Application No: FP/136/21/PL
Site Address: Beachcroft Hotel Clyde Road Felpham PO22 7AH
Description of works: Re-modelling of existing swimming pool with re-clad elevations and private roof terrace over. This site is in CIL Zone 4 (Zero Rated) as other development.

Thank you for your internet representation made on 16th July 2021 which has been recorded as an objection with the comments as follows:

Proposed Roof Terrace Plan

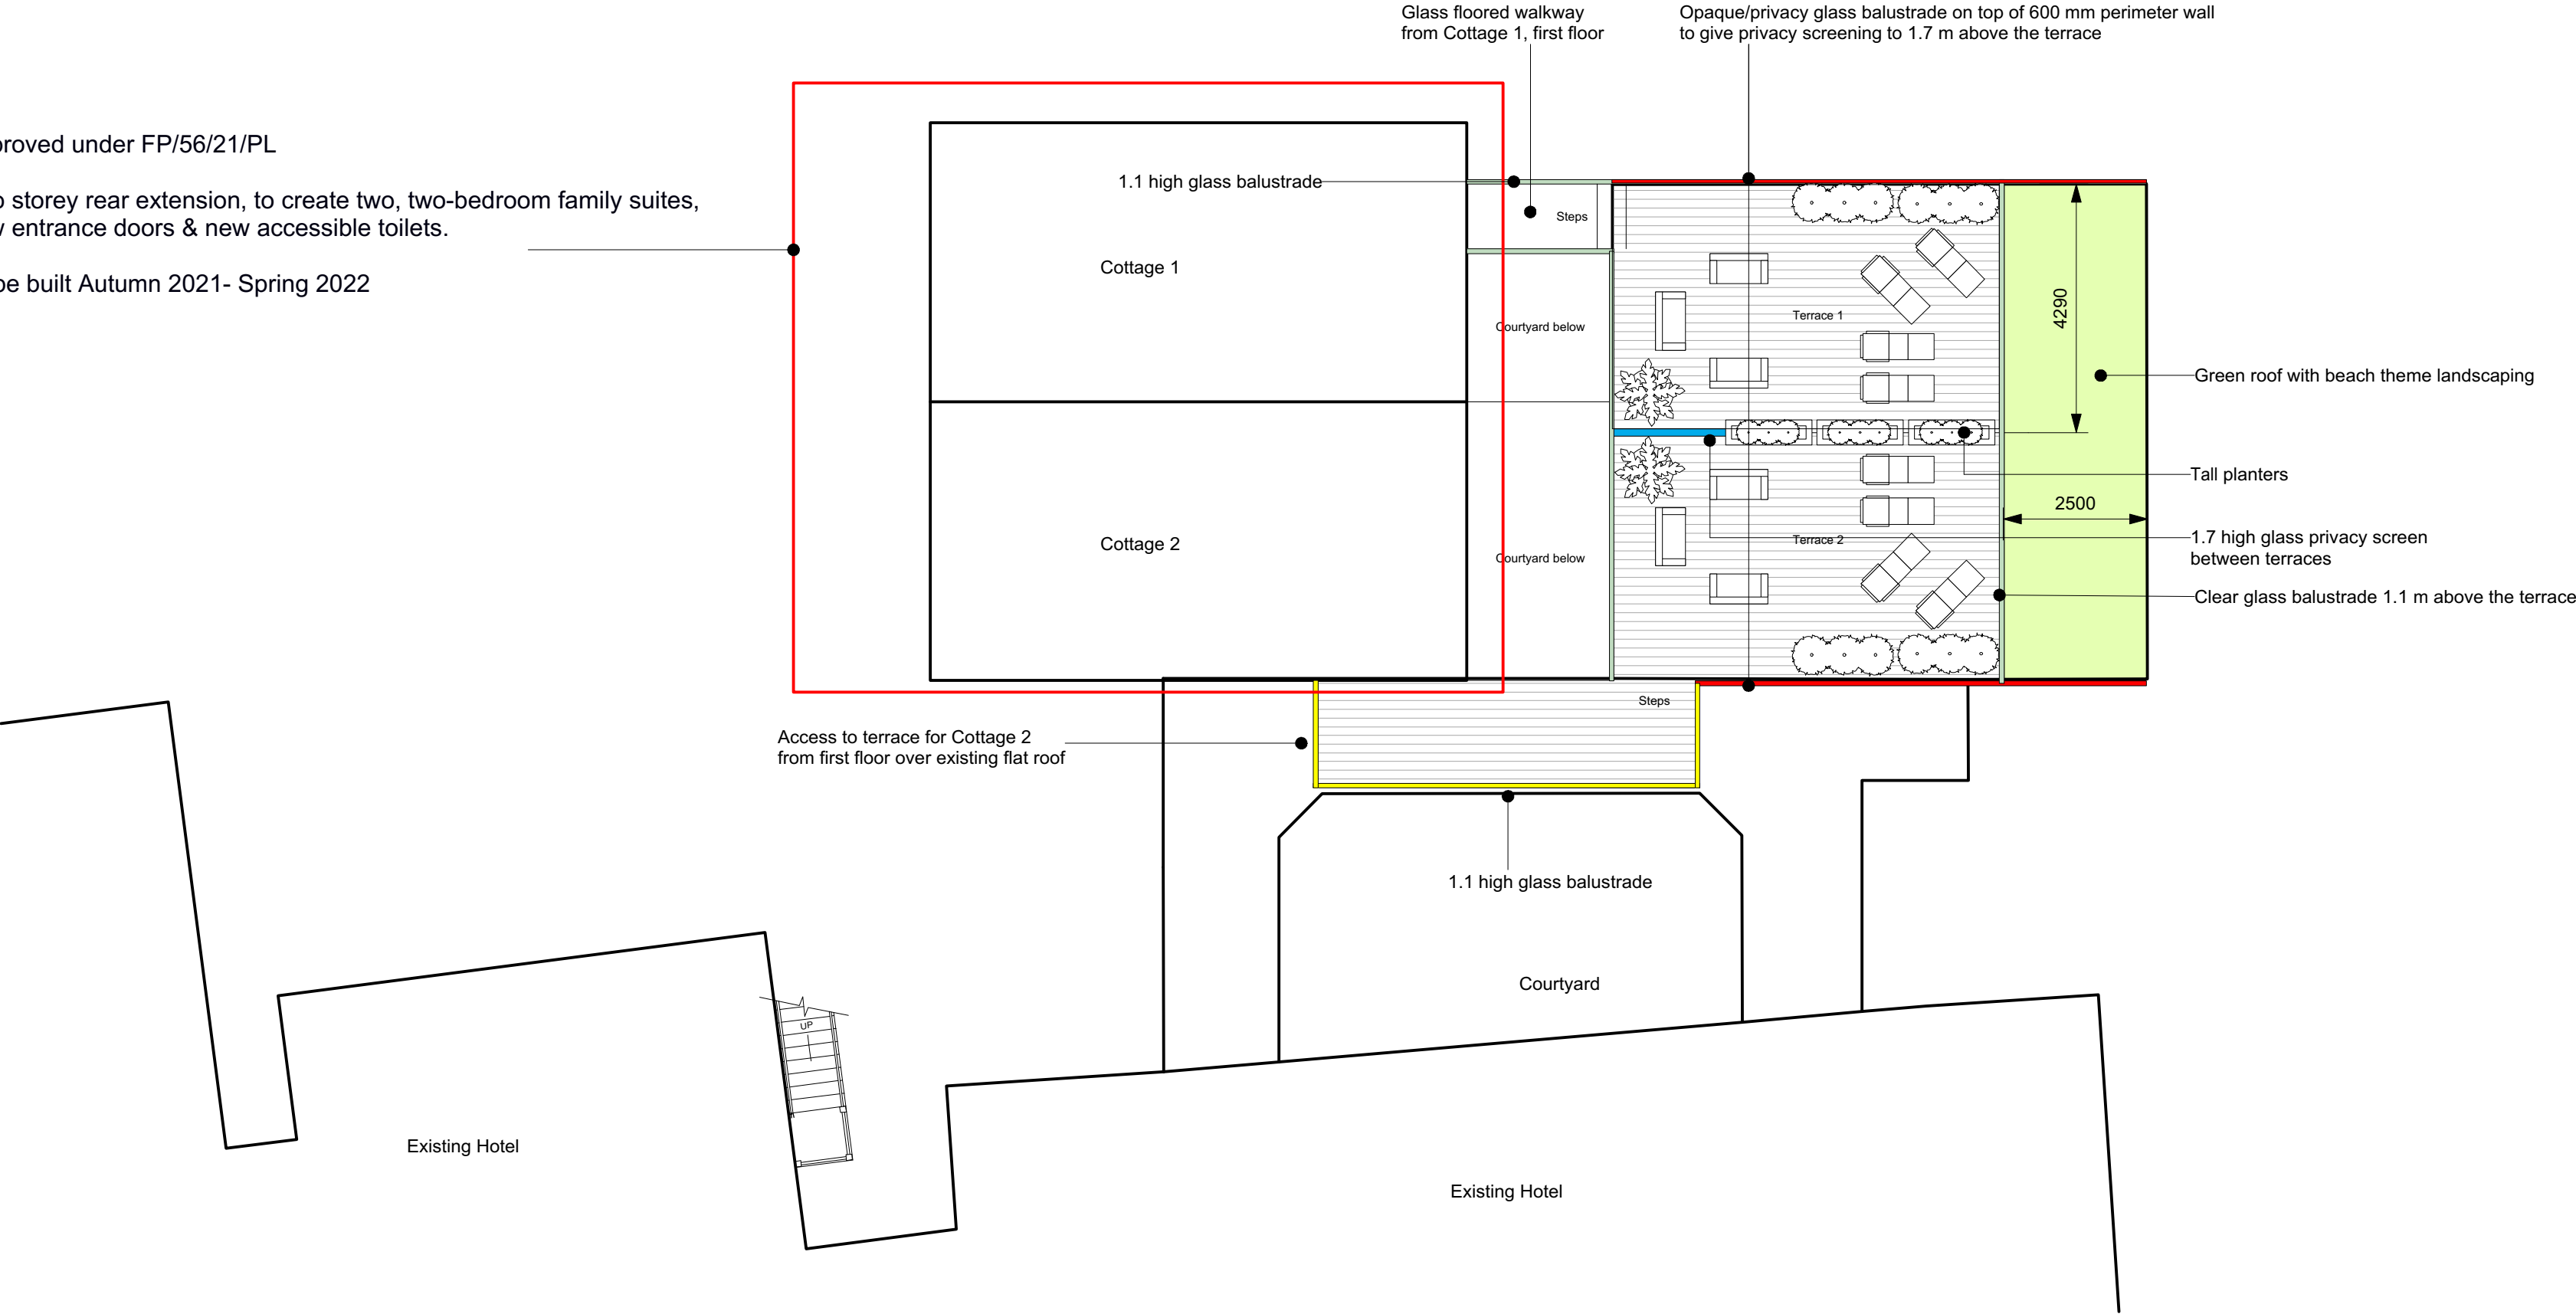
On behalf of Canning Court Management Company Ltd and the 8 lessees of the above property, we strongly object to the proposal of the development by the Beachcroft Hotel's proposed plan to put glass terraces on top of the swimming pool roof.

This proposal would be an intrusion to the privacy of all 8 flats at Canning Court which are situated directly opposite to the proposed development.

The proposal would face Canning Court flats which are parallel to the project. The flats would look directly out on to the terraces and the people on the terraces would have uninterrupted views into the flats. In addition there is potential for excess noise during the day and unsocial hours which would affect the quality of the lives of the flat owners.

We would like to point out that the distance from the proposed terrace to the windows of our flats would only

be 14 metres. We believe this would be against planning regulations as it is below 20 metres.

The proposed terraces could also have the potential to be used for functions by other people and non residents and not solely for the use of the cottages, creating the potential for further invasion of privacy and further excess noise at all hours of the day.
